| Application number: 2022/93345   |                                                          |
| What is the application for?:    | Erection of one dwelling with detached workshop          |
| Address of the site or building: | adj, 178, Deighton Road, Deighton, Huddersfield, HD2 1JJ |

Proposed Site Plan (1:500 @ A3)

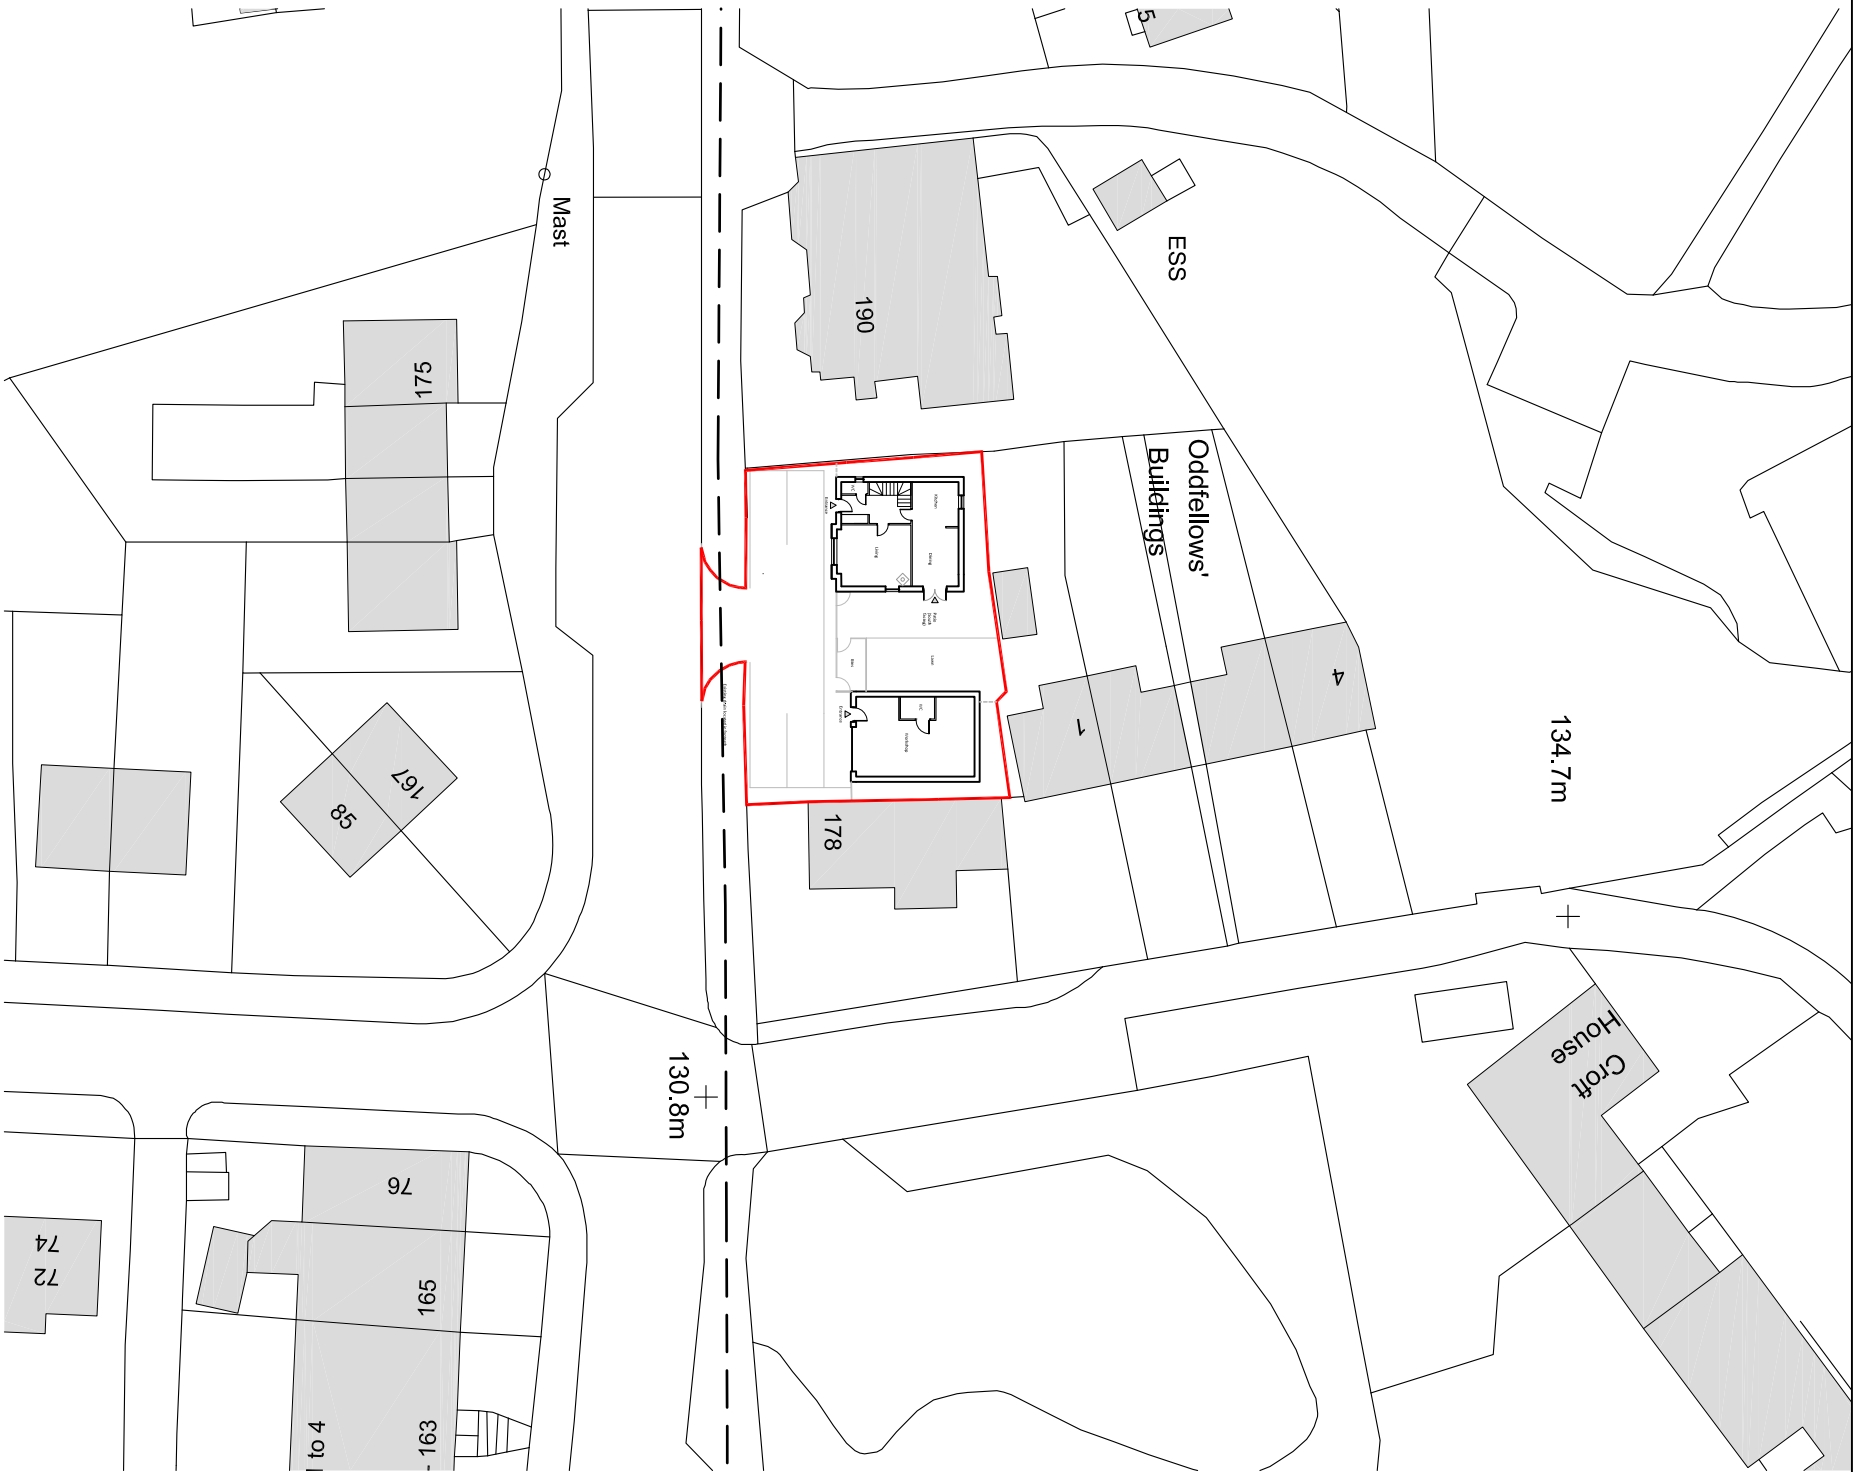
| <p>The plans do not provide any of the access, Oddfellows buildings have been offered as easement in the past, for the placement of wheelie bins from the rear of our properties to Deighton Road. It is a requirement from Kirklees council that we take the bins to Deighton Road and there is no other safe way of doing so from the back of the building, where the bins have been situated since the council introduced the use of wheelie bins.</p> |     |
